NEAR NORTH VALLEY NEIGHBORHOOD ASSOCIATION

December 15, 2021

Re: Brown Property (Calle Cuarta) redevelopment
PR-2020-003847; site plan for the East Parcel

SDP1.1

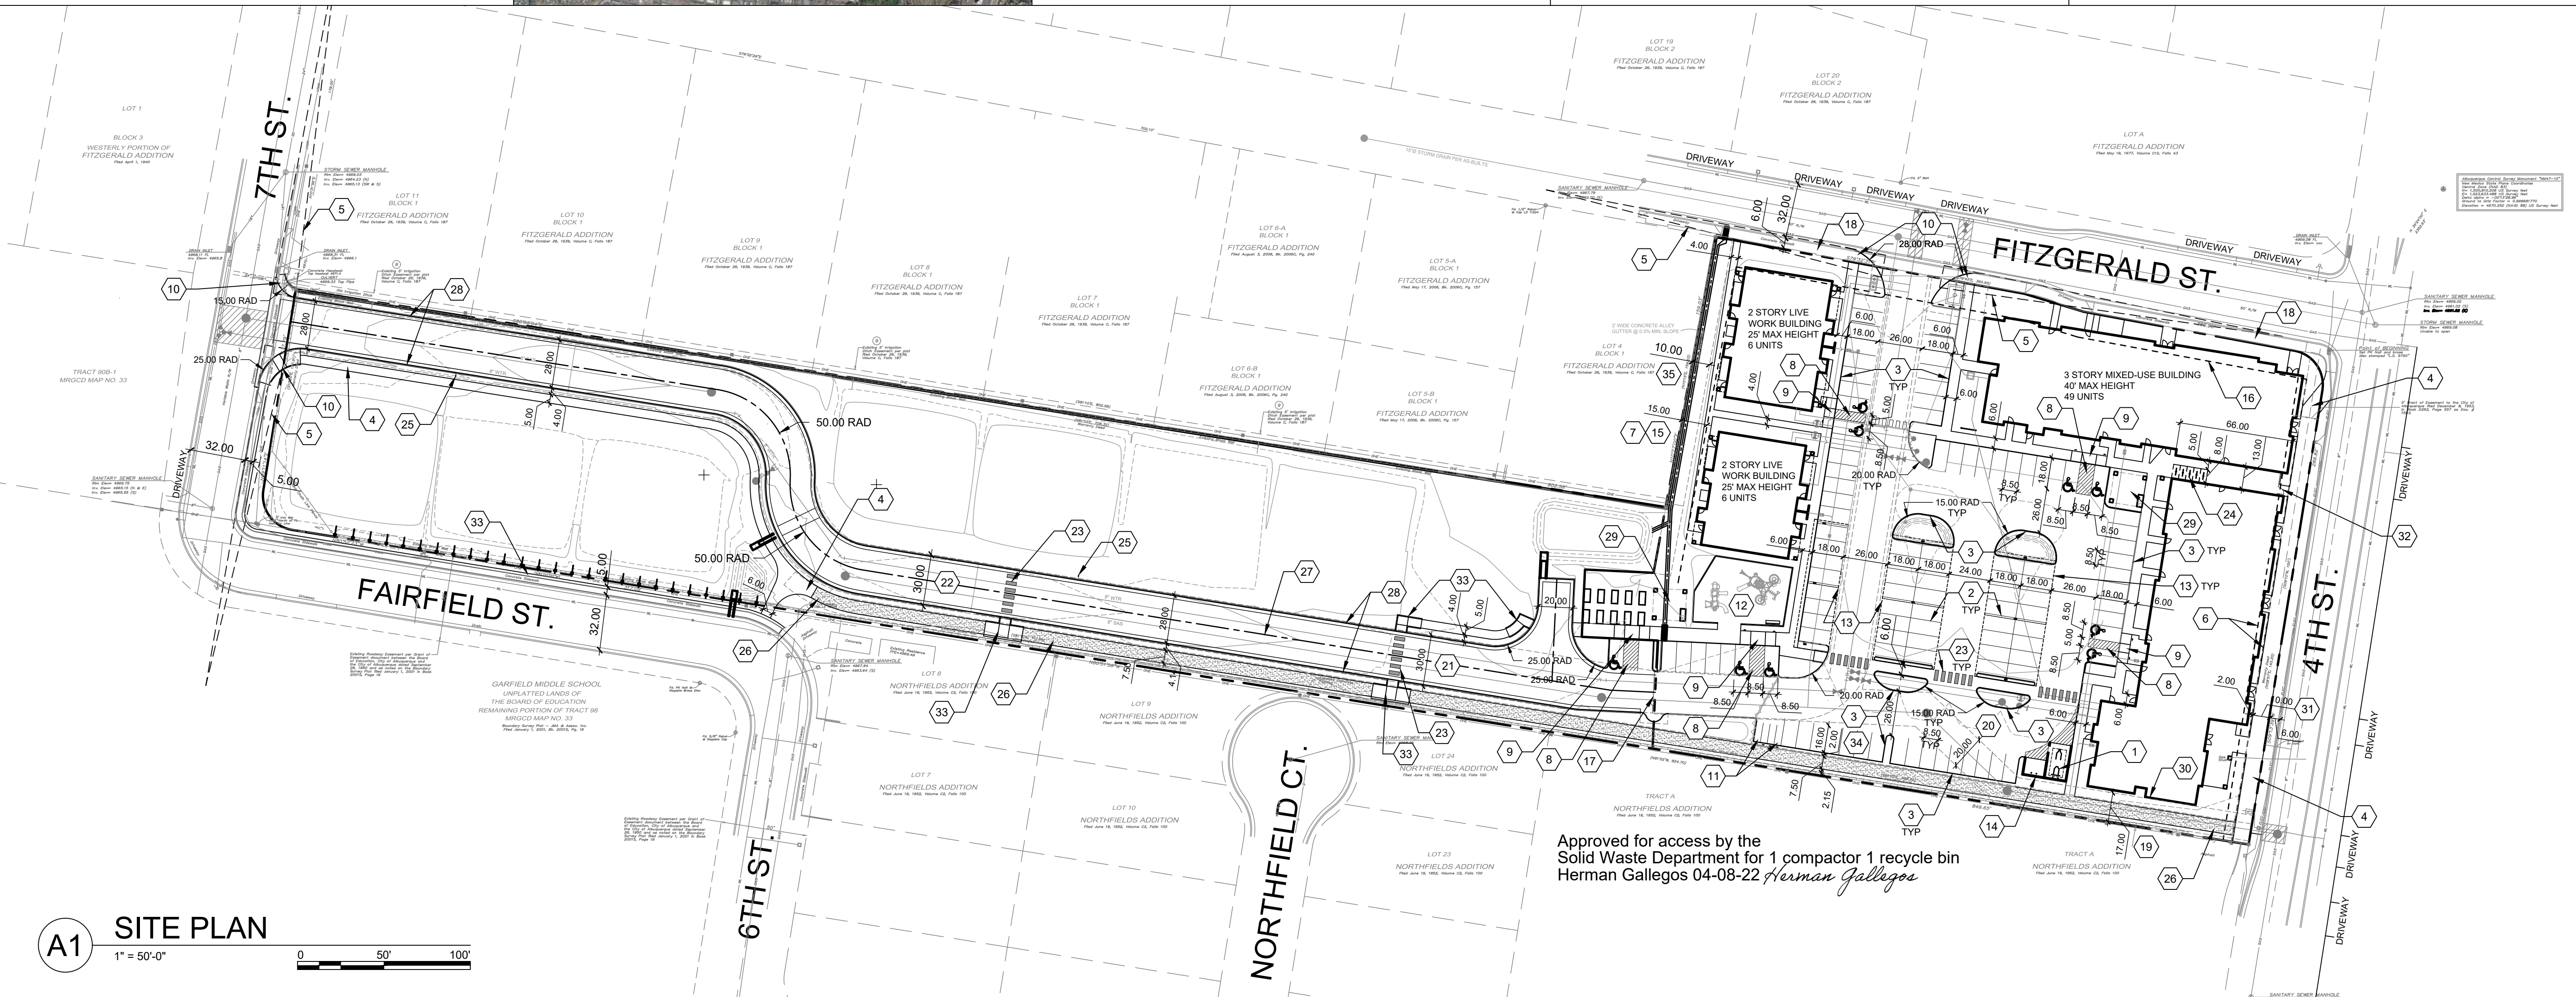
1. **Protected left turn lane on 4th Street.** A left turn from northbound 4th Street onto westbound Fitzgerald Road will be the primary route for tenants and customers to access the parking lot for this high-density housing and commercial project. In the current roadway configuration, there is no safe and efficient way to turn left off 4th onto Fitzgerald. Because turning left off 4th is a necessary traffic movement for the success of this project, it is essential that a safe and efficient left turn lane is provided. If restriping does not resolve the issue, then it must be resolved by moving the curb and adjusting the site plan.

2. **Vehicle barrier between East Parcel and West Parcel.** From the outset of planning for this project, it has been understood that only emergency traffic would be allowed between the East and West Parcels. The RFP explicitly stated that a vehicular connection between the high-density East Parcel and low-density West Parcel should be avoided (Brown Property RFP, page 5, attached). Based on our review of the proposed site plan, it does not appear that an emergency gate blocking traffic between the two parcels has been included. This must be addressed.

3. **Streetscapes.** The details for the streetscapes along 4th Street and Fitzgerald Road are not clear from the site plan or the landscaping plan. How do these streetscapes satisfy the Main Street requirements, the Street Tree ordinance, and the IDO/DPM profiles? How wide is the sidewalk? How wide is the planting area? How is the planting area configured? Is it wide enough to support healthy tree growth? Will there be intermittent hardscape connections between the street and sidewalk in the event that on-street parking is added? It does not appear from the site plan that the streetscape follows the required curb/tree-lined buffer/sidewalk profile, although illustrations presented to the community in August do indicate this profile. (See attached 8-18-2021 PowerPoint presented at NNVNA's Annual Meeting.) Detailed profiles of the streetscapes on both 4th Street and Fitzgerald Road should be provided to the DRB to evaluate.

5. **ADA Parking.** It appears there are only six handicapped parking spaces. Is this enough for an apartment complex expected to attract low-income seniors? There’s also no covered ADA parking and no ADA parking near the community open space/play area.

6. **Compactor/refuse areas.** We very much appreciate that the compactor and the accompanying refuse enclosure were moved away from the play area.
7. **Pedestrian/bike path along the south.** Pedestrian/bicycle connectivity through the new development to 4th Street was identified as an important community objective. The sidewalk/bike path along the southern boundary of the property is meant to accommodate various pedestrians—couples, groups of school children, parents with strollers, people in wheelchairs, etc.—and bicyclists coming to and from the surrounding homes, the school, the expected restaurant, and other businesses. It’s the primary link integrating the existing neighborhood with the new development. The sidewalk/path appears to be five or six feet wide. That’s not wide enough. It should be a minimum of eight feet wide to comfortably serve its purpose; 10 feet in width is preferable. In addition, there is no buffer nor landscaping between the sidewalk/path and the street/parking, and few trees. With careful adjustment of the covered parking area, enough space could be captured to provide adequate sidewalk/path width, a narrow planter along the property wall and buffer planting between the sidewalk/path and the parking creating a path that is clearly perceived and functions as a public way. A detailed profile of the pedestrian/bicycle path should be provided.

8. **Pedestrian path/bridge over the drainage areas along the covered parking.** The site plan indicates drainage areas at both ends of the

covered parking, with a pedestrian path over the drainage areas on the south end. What are the details for these pedestrian “bridges?” How will they be made safe and accessible for all persons, including children and the elderly? Details should be provided. As an aside: it may make more sense to place this pedestrian crossing at the north end of the covered parking. That would better keep people, especially children, from cutting across the parking lot to the community space/play area.

9. **Live/Work access.** The westside entries to the live/work units raise CPTED and ADA issues. These entries are located in a narrow space between the back side of the buildings and an existing high property wall. As a consequence, the entries are hidden from public view and pose a potential safety risk. The entries could be moved to the north and south sides of the buildings where they would be visible from public parking areas.

15. **Note errors?** On the first sheet under "Amenities," a clubhouse, swimming pool, and spa are mentioned. Have these features been added to the project? Also on the first sheet, under "Project Data," the bus routes mentioned do not appear to be relevant to this project.

LANDSCAPE PLAN
 1" = 50'-0"
 NORTH

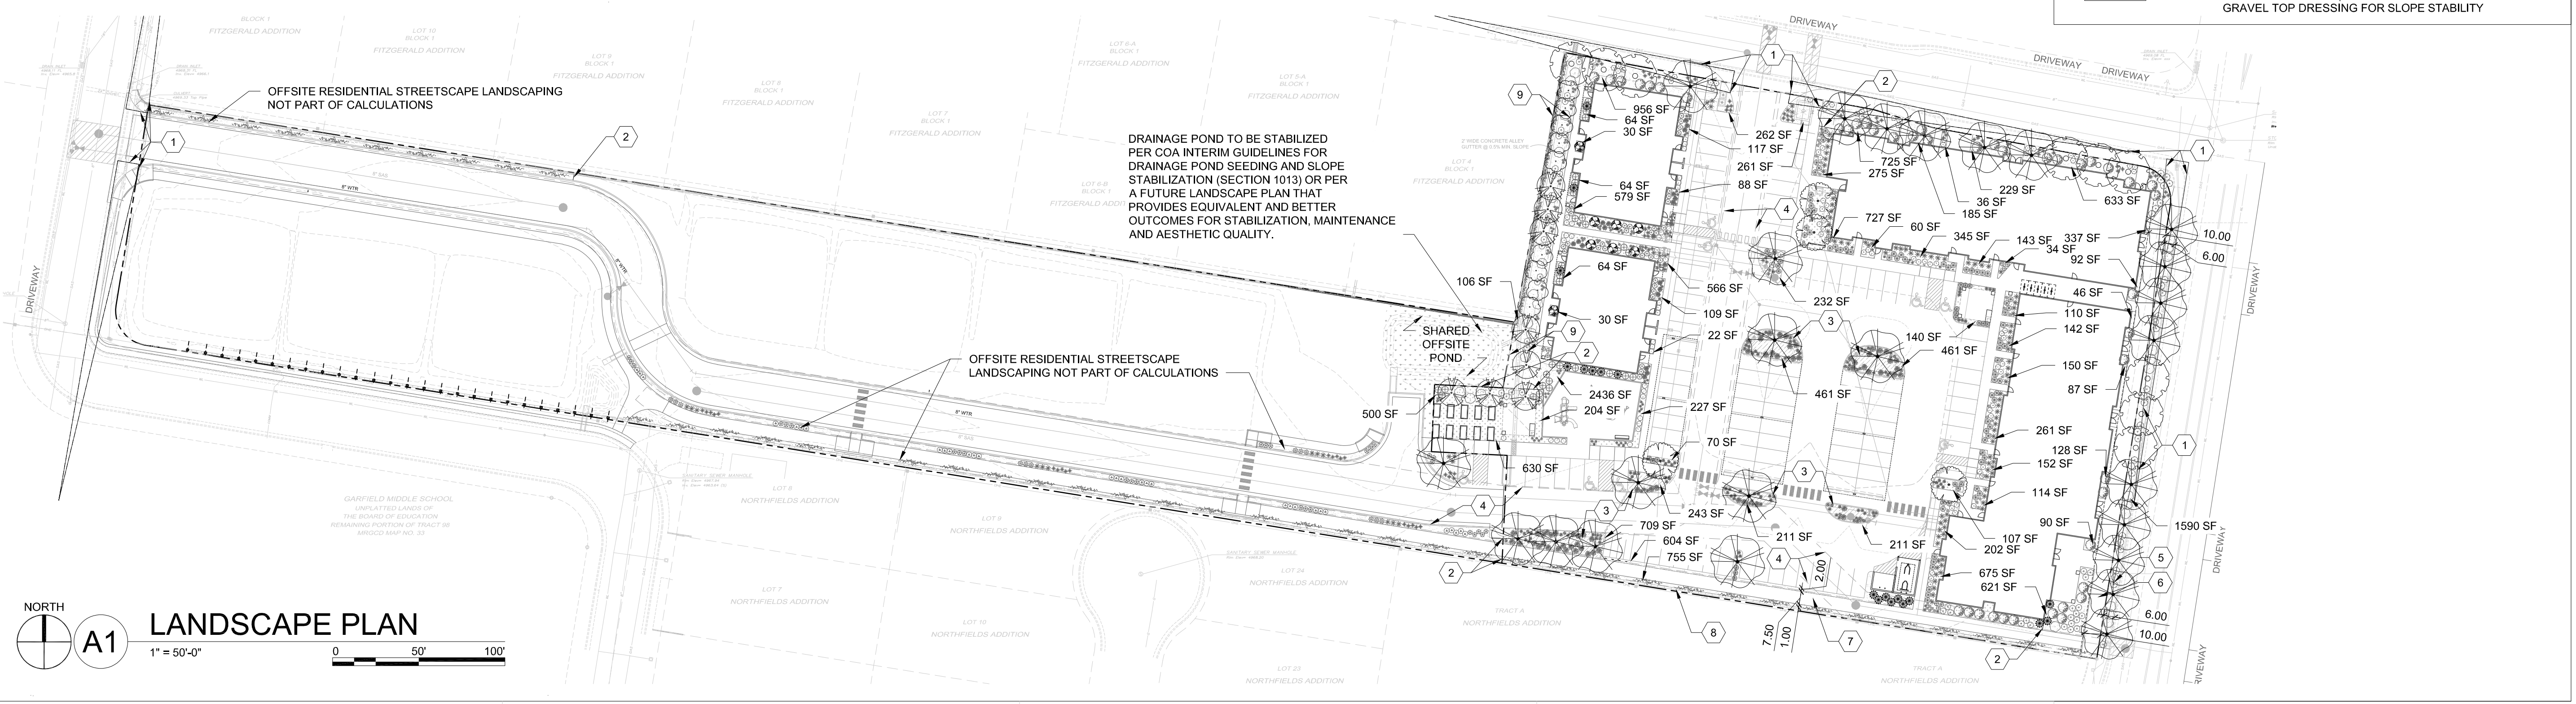
13. **Landscaping.** Generally, there are not enough trees, especially along the sidewalks that circle the parking area. This came up in one of our previous

meetings and we were assured that there would be a ring of trees along the sidewalks. This would be especially important in providing visual respite for the apartments and live/work spaces facing the internal parking areas.

D1 DRB BUILDING 3 - NORTH ALONG FITZGERALD
3/32" = 1'-0"

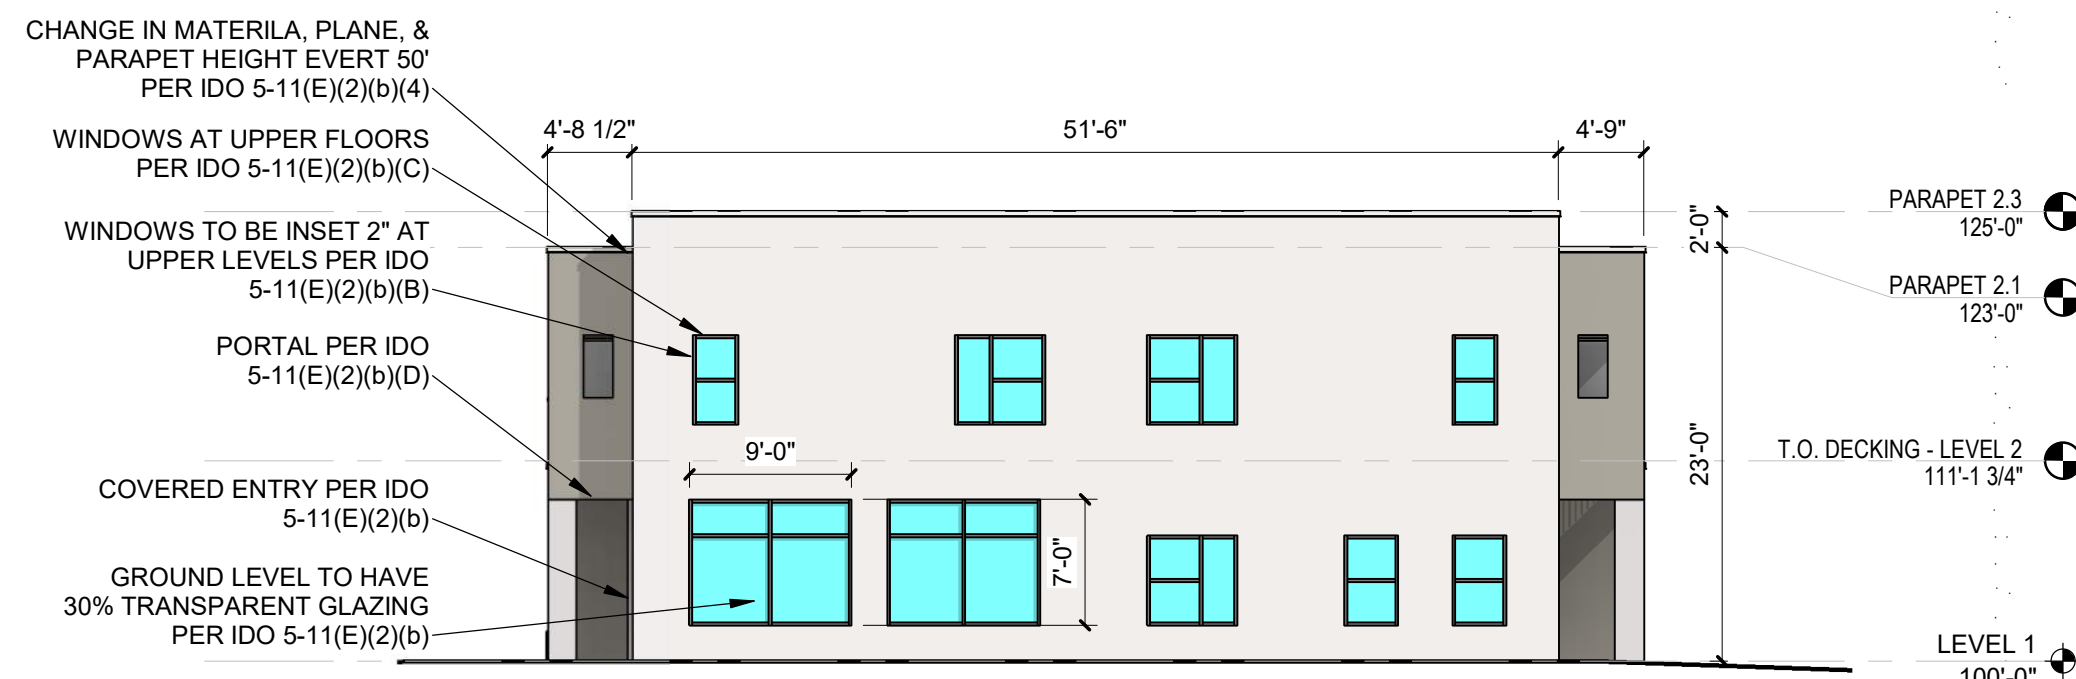
10. **Step-back/facades/articulation, along Fitzgerald Road.** Are step-backs required along Fitzgerald Road as they are along 4th Street? The north face of the building would appear much less massive and hulking with a third-floor step-back. And, whether or not it meets the technical articulation requirements, the northern façade in particular lacks sufficient articulation to be visually pleasant and to reduce its massive look. The last block of apartments—going west—is particularly plain, both on its north and west faces.
